From: Michael Eastham
Sent: 29 August 2017 10:15
To: Planning.Responses
Subject: FW: Objection to application AL/83/17/PL

The Nook, Hook Lane
Aldingbourne
Chichester
West Sussex
PO20 3TE
28th August 2017

Planning Application AL/83/17/PL

PROPOSED SOUTH ELEVATION

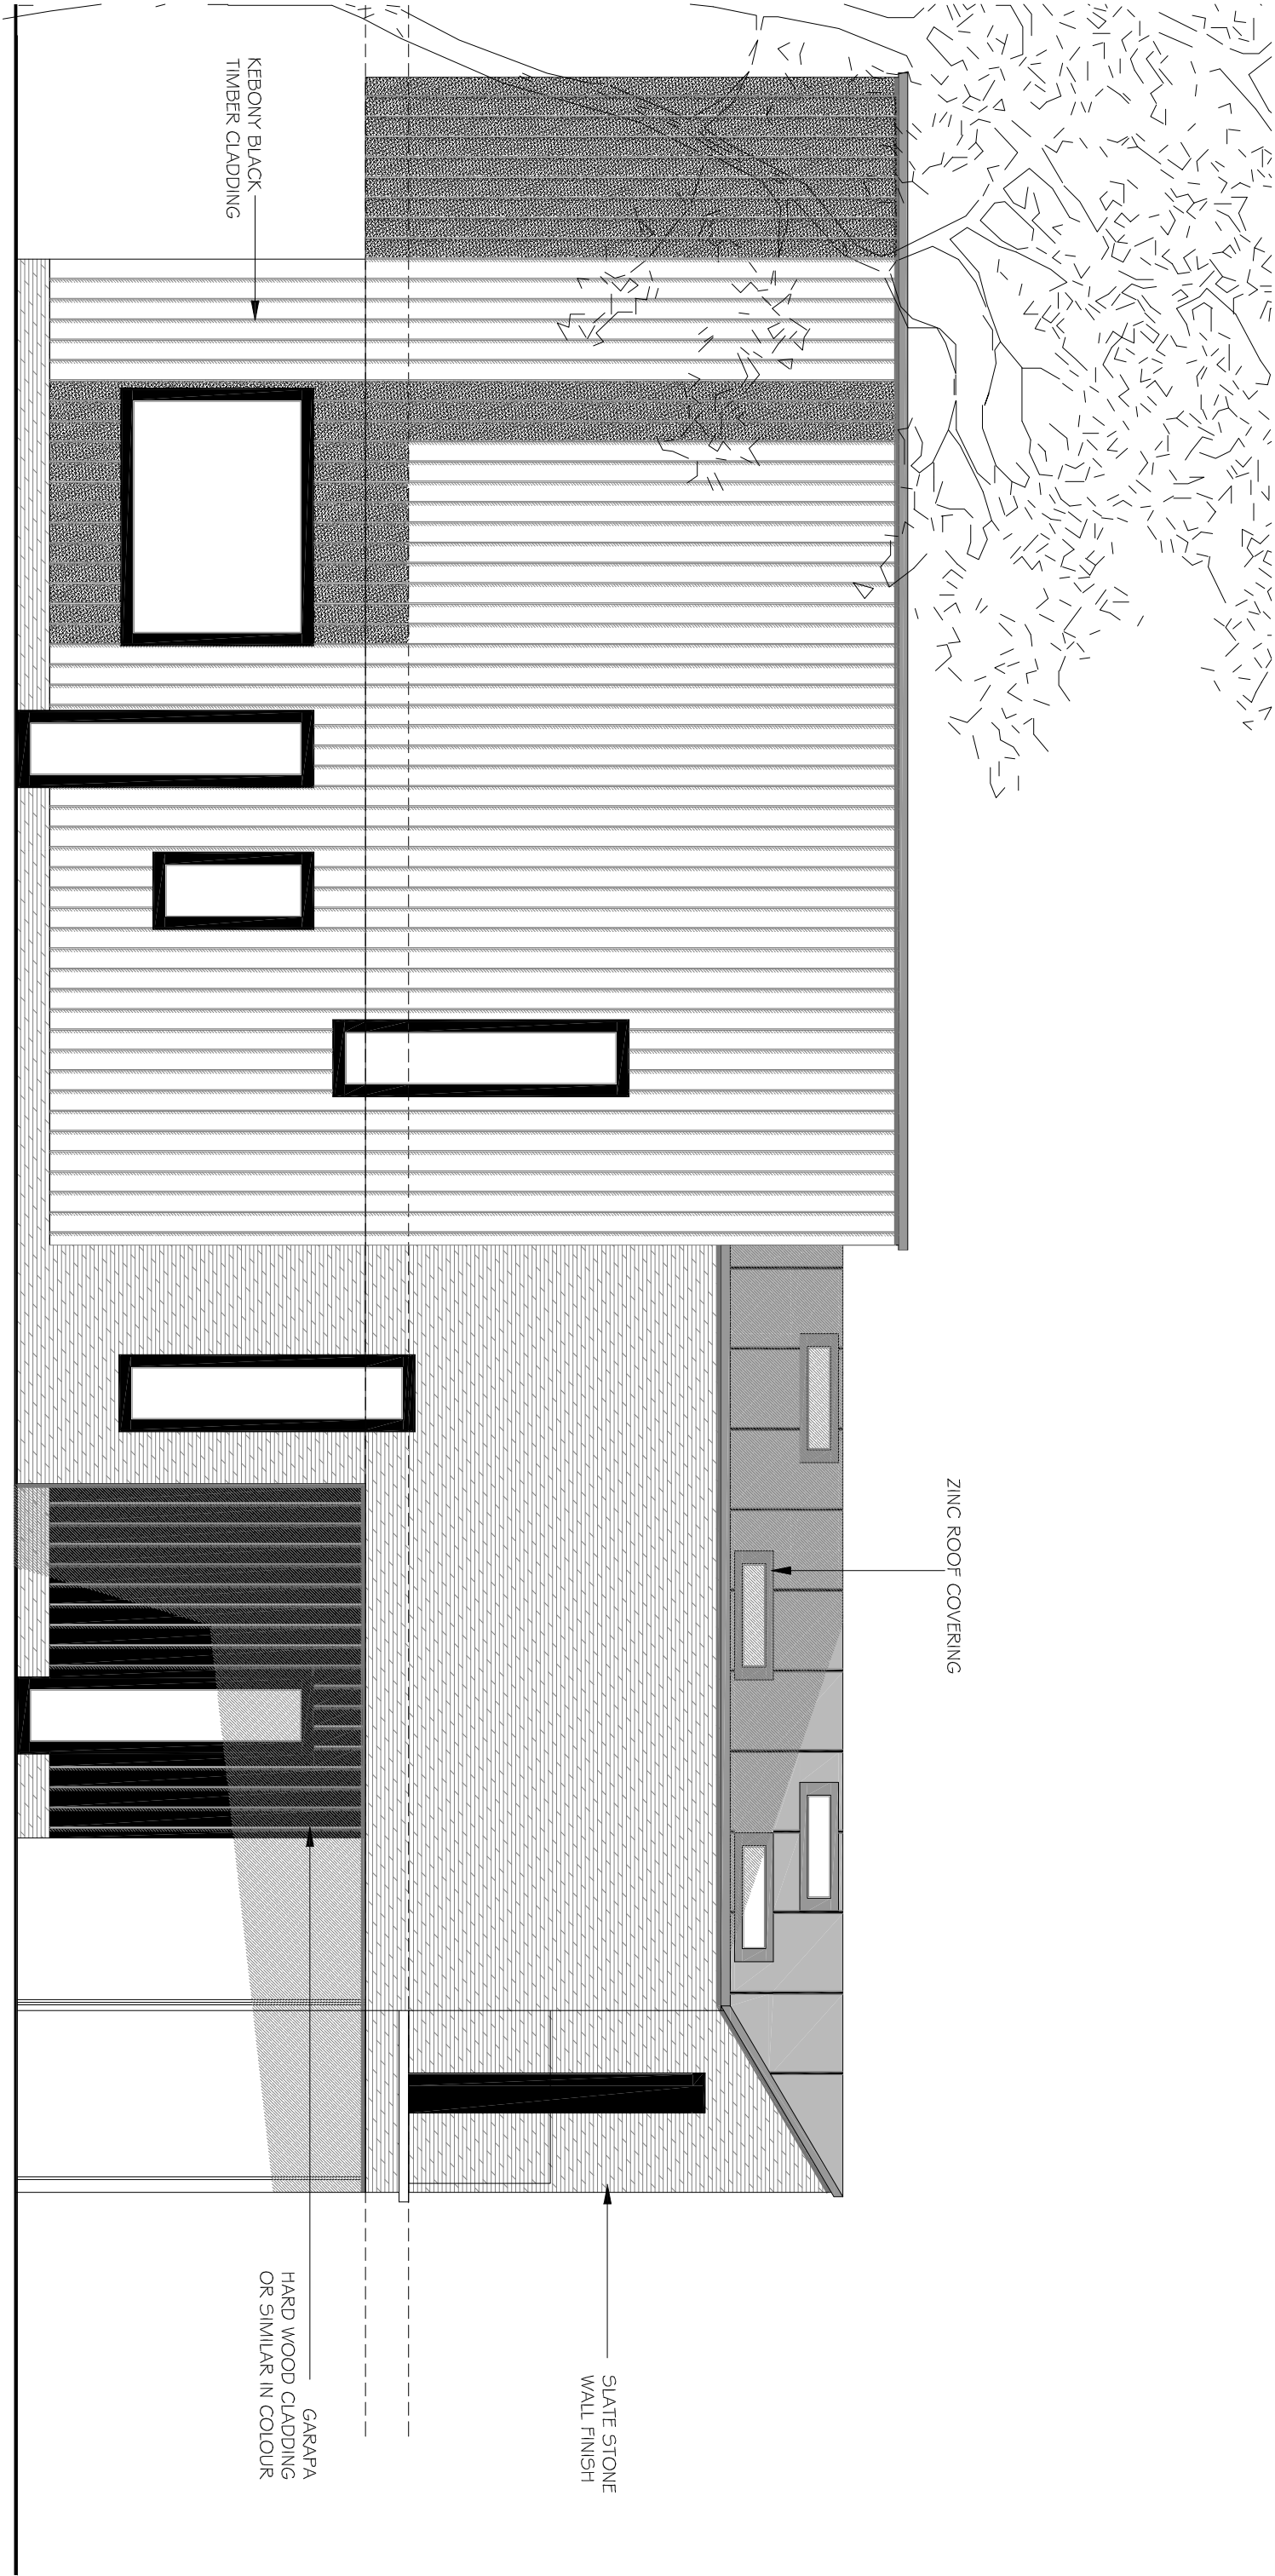
Policy Gen 7 of the Arun Local Plan states that developments should not have an unacceptable adverse impact on adjoining occupiers, land, uses or property. In seeking to generate additional floor space by building upwards and outwards, the dwelling will be virtually double the height of the existing property and will abut the property boundary on its north side. This represents an unacceptable loss of amenity for the neighbouring property, in particular with respect to the large shadow cast on the neighbouring property.
